Landscape Briefing Note 3

Project: 1080 East Anglia One North and East Anglia Two
Date: 10th December 2020
Purpose: Notes following Issue Specific Hearings No 2 (ISHs2)
Reference: 1080 BN03 Final Notes following ISHs2- onshore works .docx

**Viewpoint 5 Public Rights of Way, near  
Moor Farm (with National Grid GIS  
Substation)**

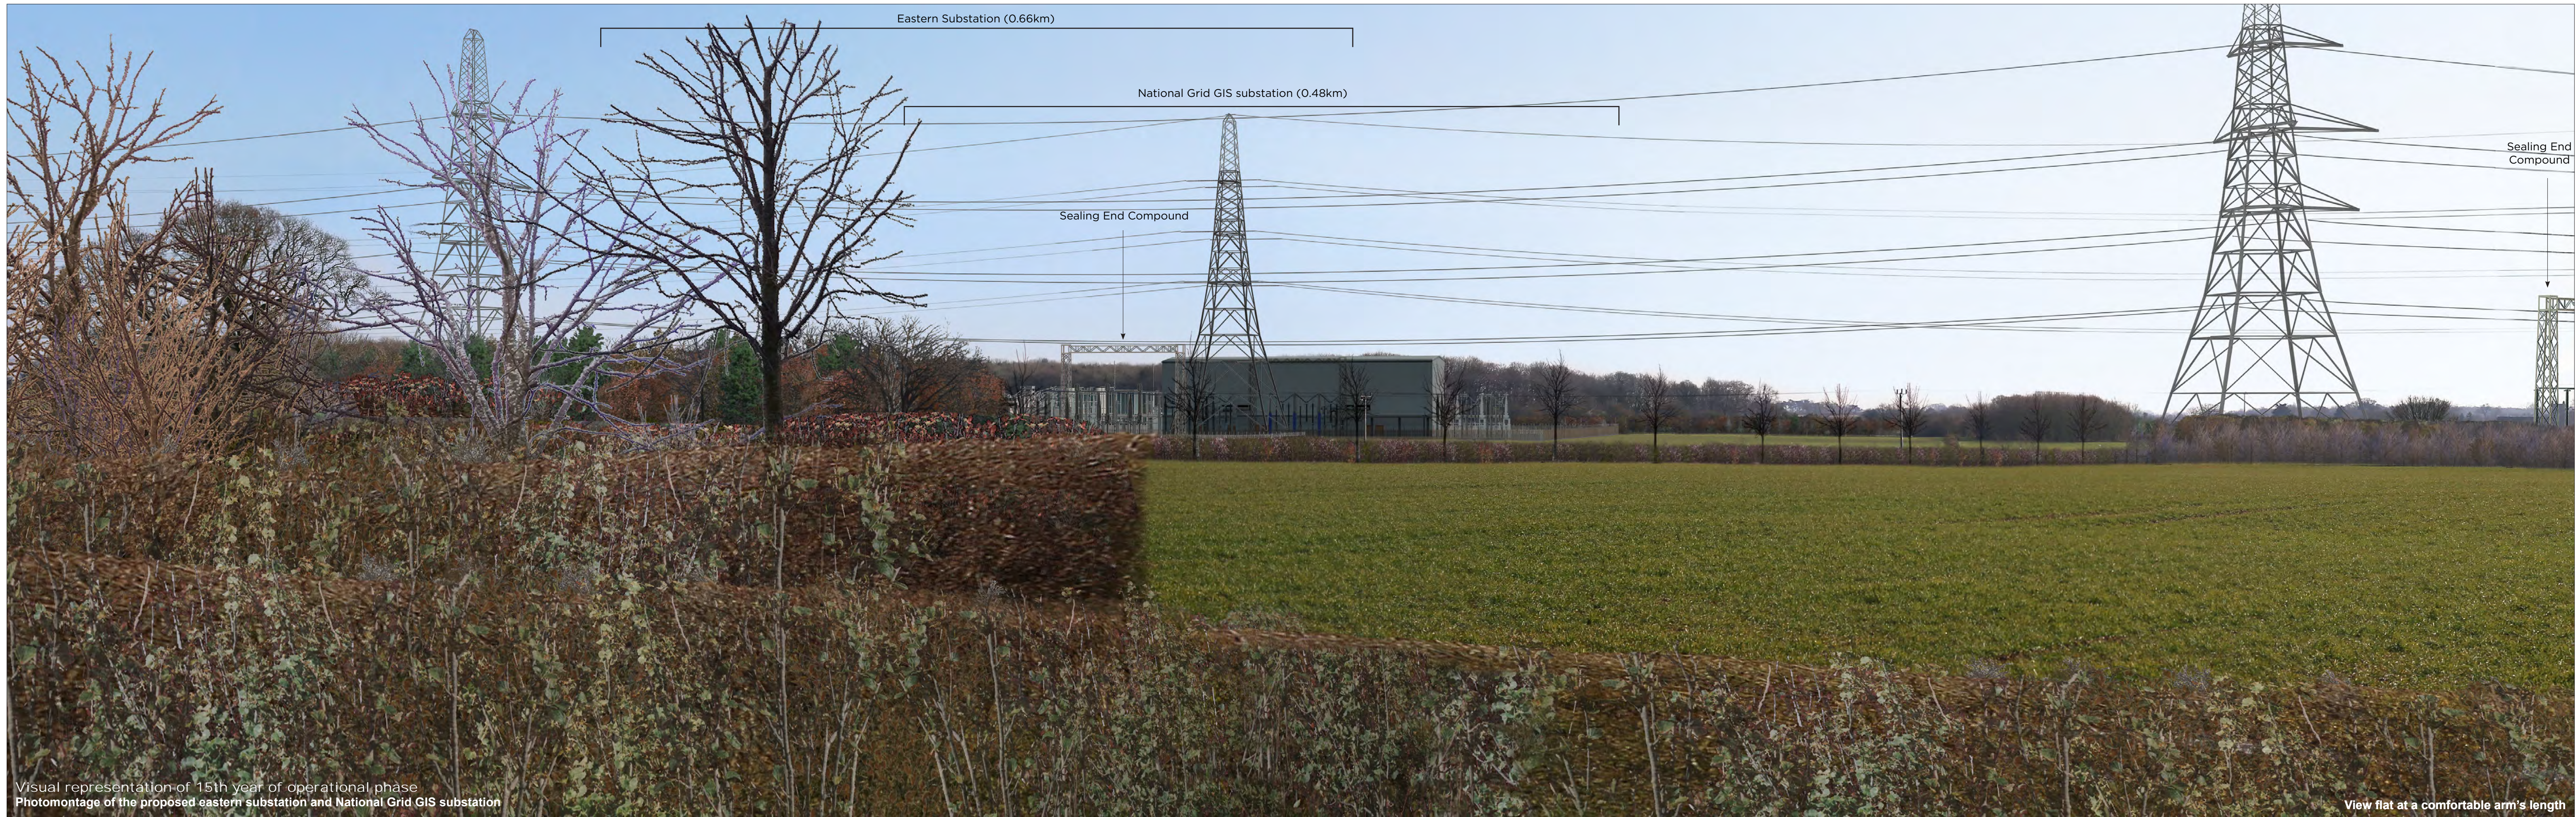
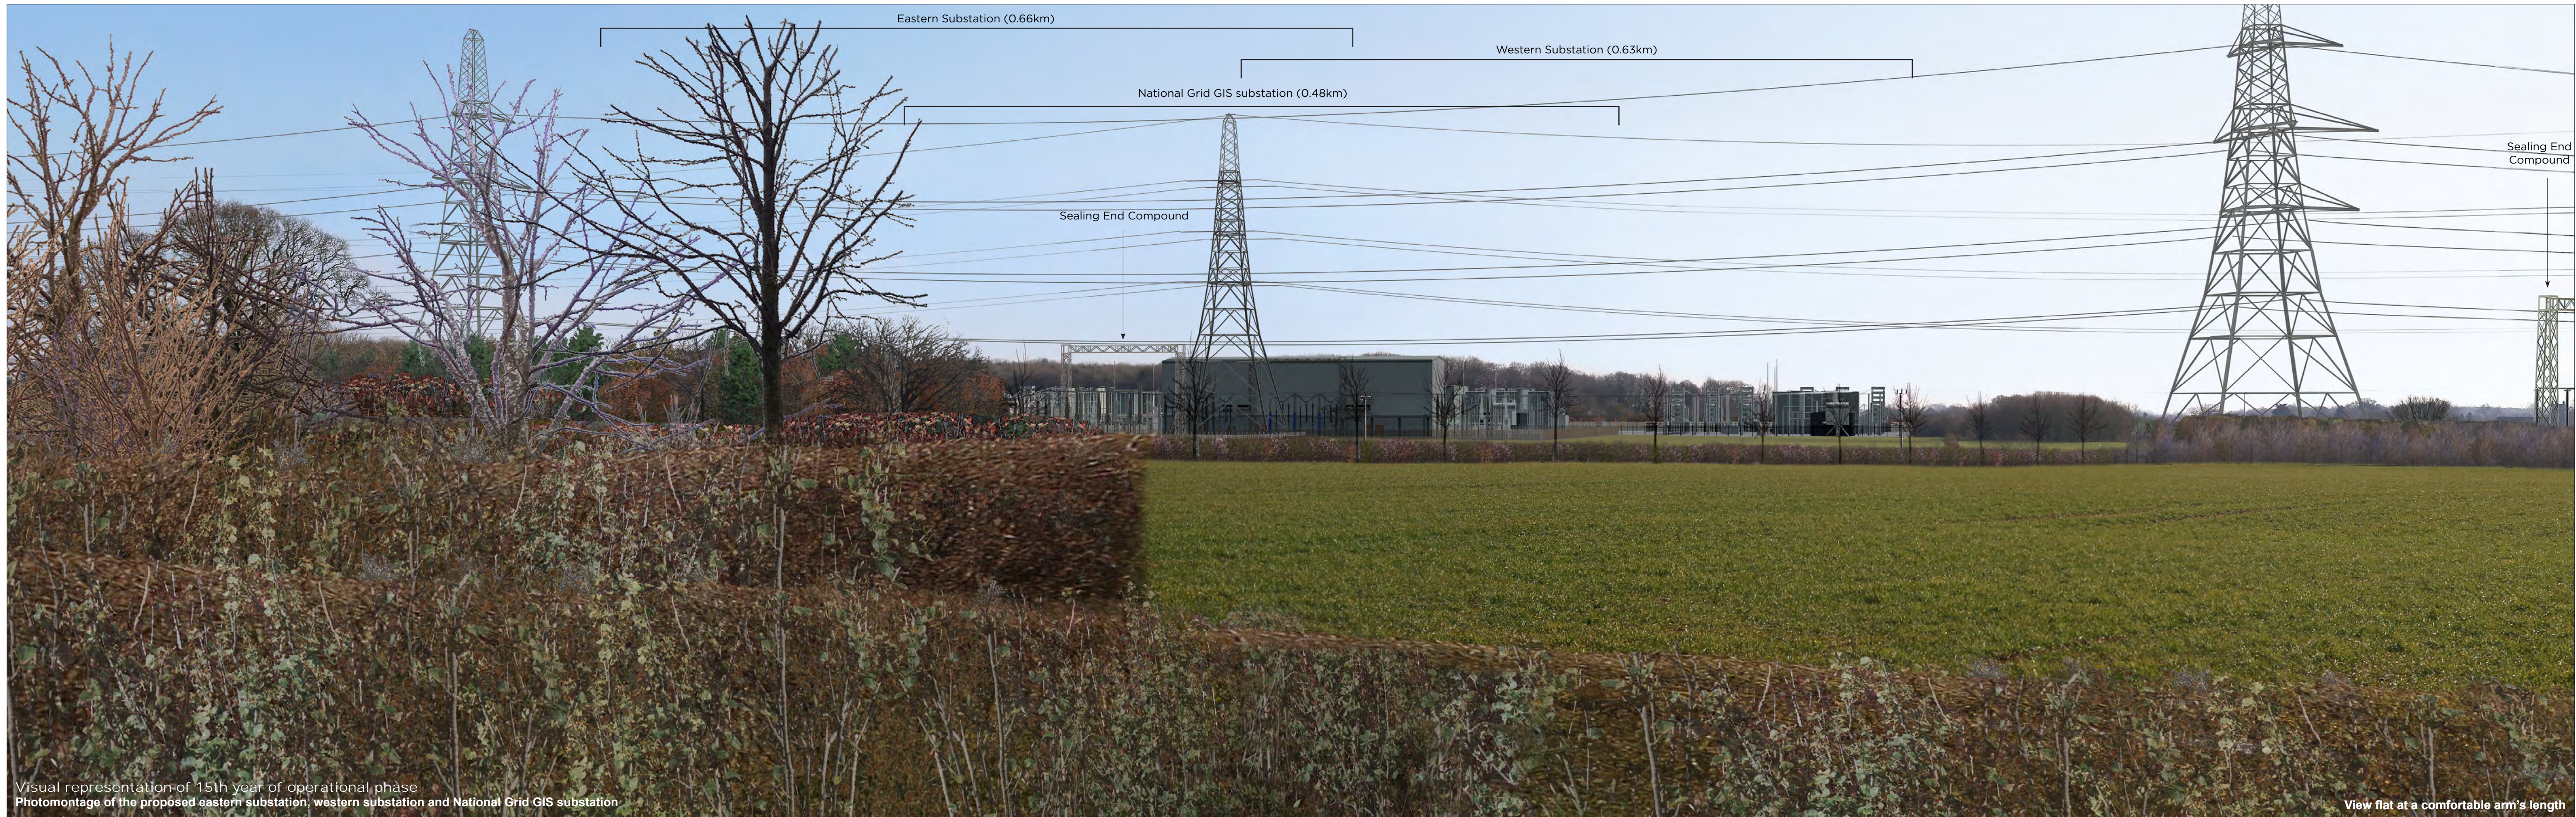
- Vp 5 - PRoW, near Moor Farm (should be High House Farm) This is an important viewpoint where an existing image at the same HFOV as the visualisation would have highlighted the view of the church on the right-hand edge of the image. This view will be seen through the most westerly (and largest) of the sealing end structures. There will be no mitigation of this visual effect after 15 years and a 'tree branch' introduced to the right-hand edge of the image is misleading. It is hoped this 'tree branch' will be omitted in the next set of visualisations.
